12th June 2017

**Re: Application FP/127/17/PL0 - 2 Second Avenue, Felpham
Proposed 4 bedroom house**

PROPOSED STREET ELEVATION

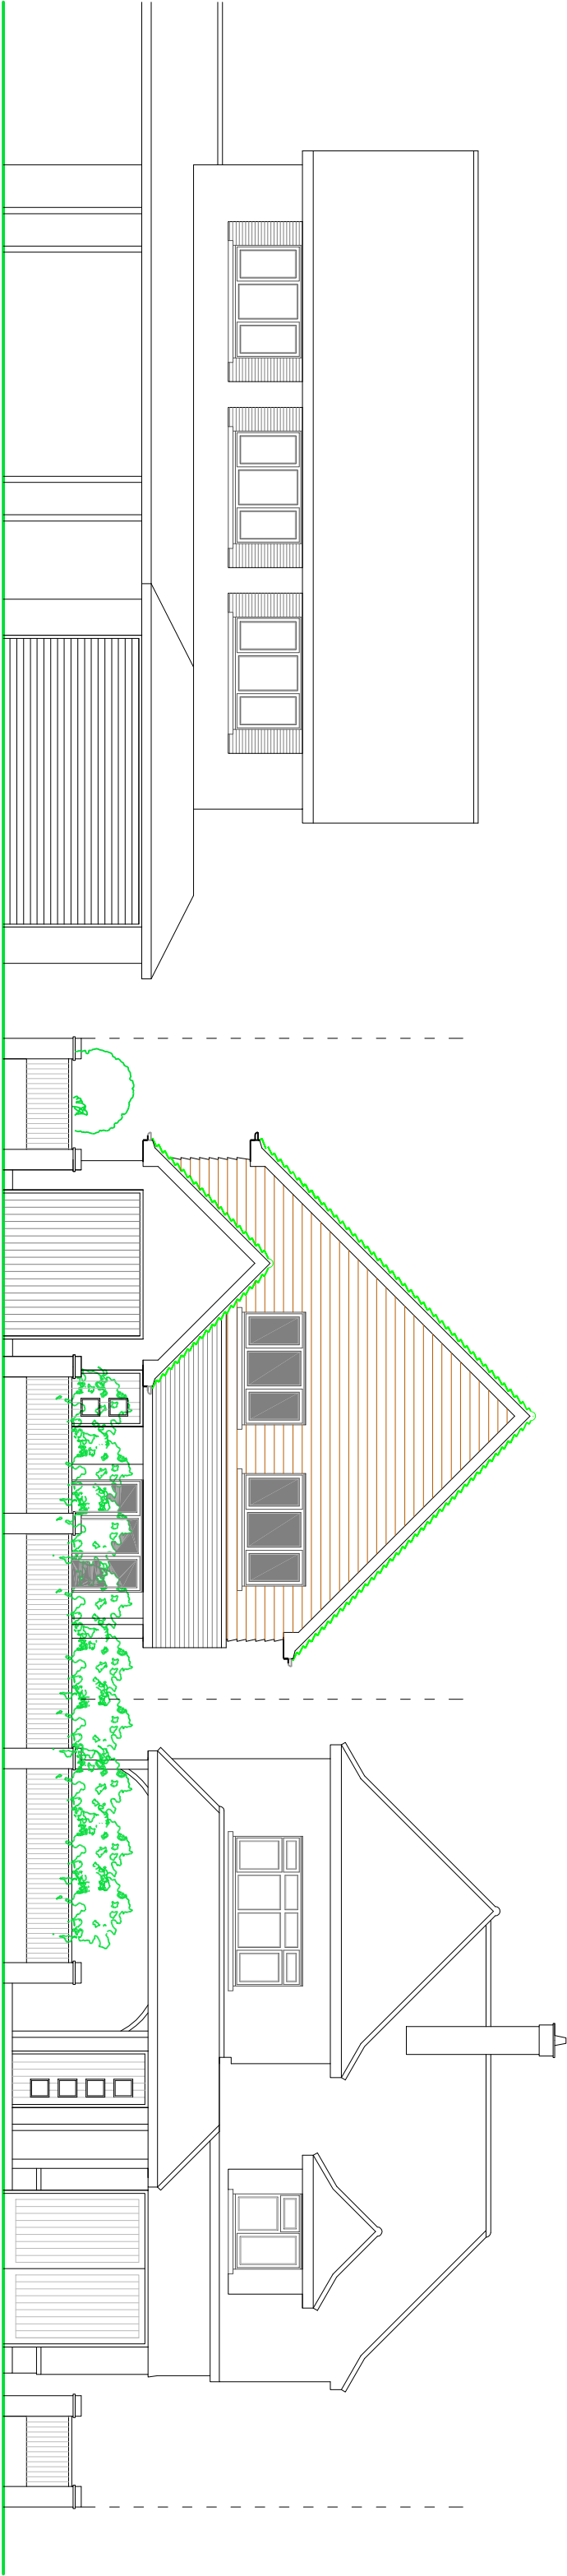
I am surprised that this further professionally prepared application also contains inaccurate plans, as did the 2007/8 Application, which are potentially misleading bearing in mind the specific nature of the application and the 'property' in question. In particular, the adjacent house to the south, Shergar, has a first floor side extension which is not shown. This omission implies a greater sense of space than exists. Please see a copy of the letter issued by Broadlands dated 15 January 2008, which remains appropriate to this application.

not on submitted plans
↓

PROPOSED PLOT PLAN

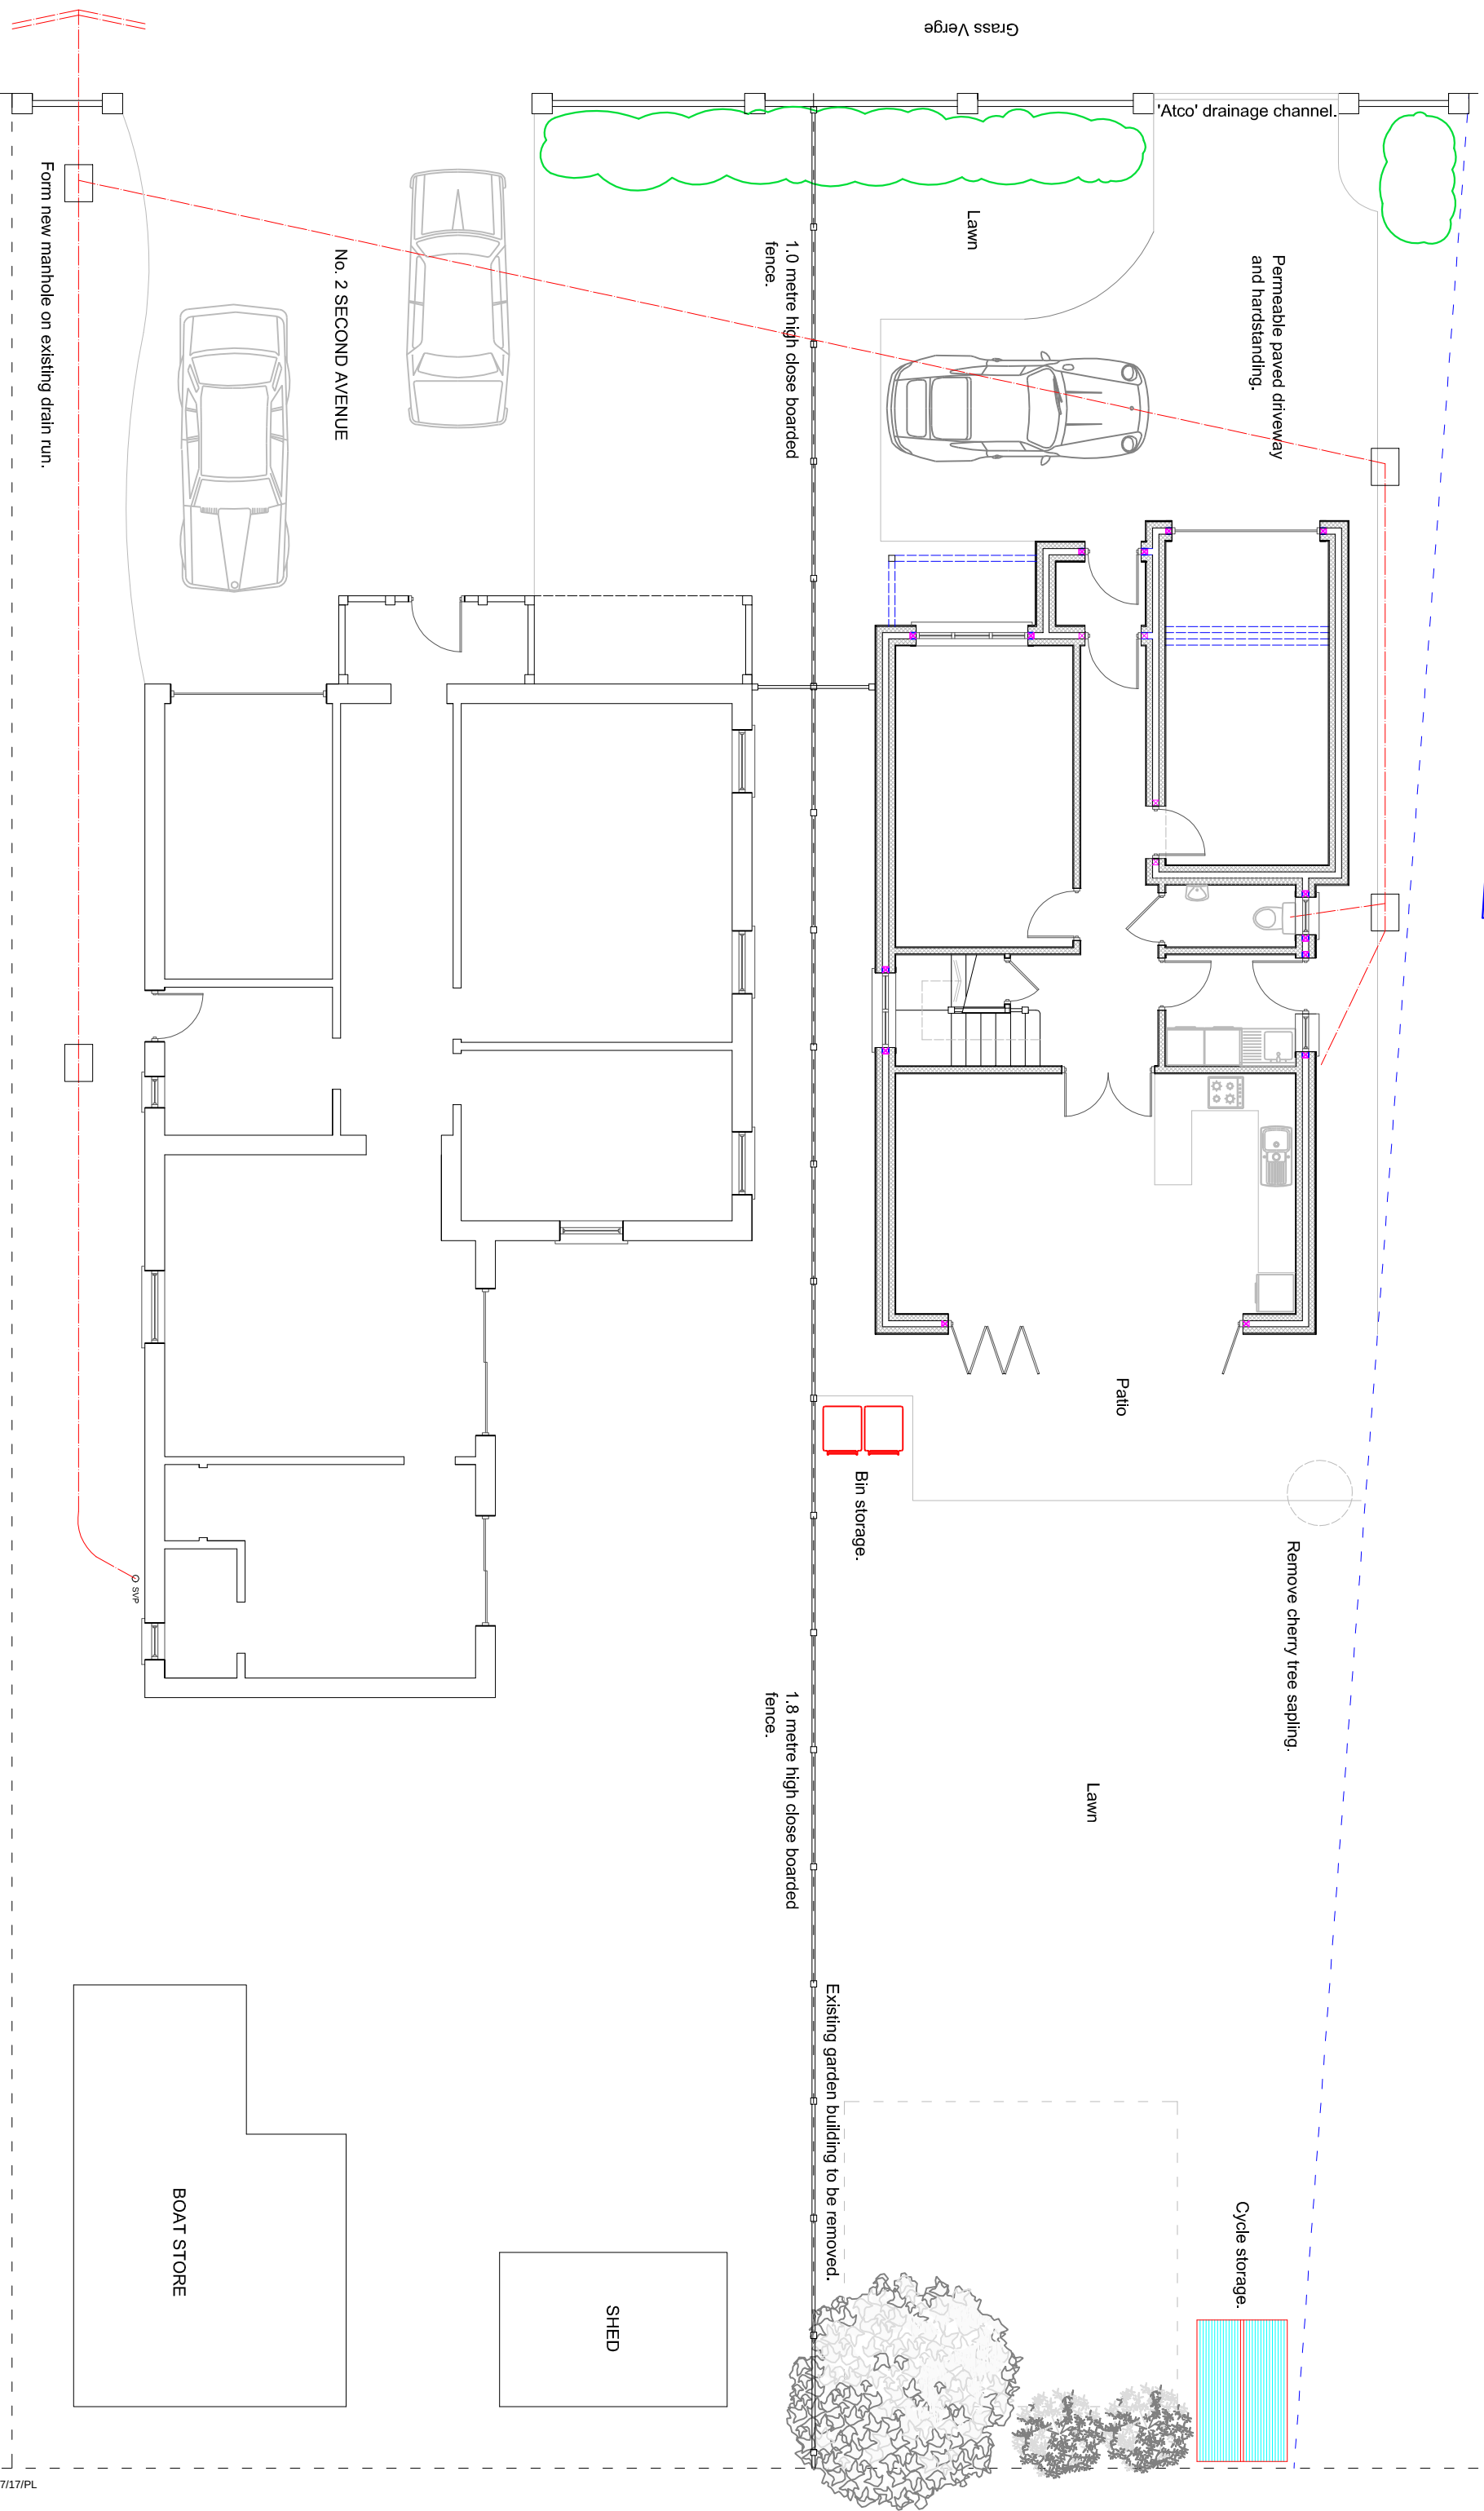
Existing plot sizes in Second Avenue are considerably wider than the proposed site, which is a little over 10m (32') frontage compared with 50' upwards for other properties. If this Application is approved, there will be two properties each with a smaller frontage than any other in this road and also on this estate (one being 32' and the existing property reducing to 41'). This is out of character and detrimental to the character and appearance of Second Avenue and the area of Summerley Estate.

I enclose two photographs taken on 1st July 2017, being the Saturday after the Application Notice was pinned to a fence. This Notice has since disappeared. These pictures show that there are already a 'more than usual' number of vehicles linked with the activities of the Applicant. Parking is already a problem most weekends and a further property on such a narrow plot with two or more cars will create an even greater problem affecting neighbouring properties.
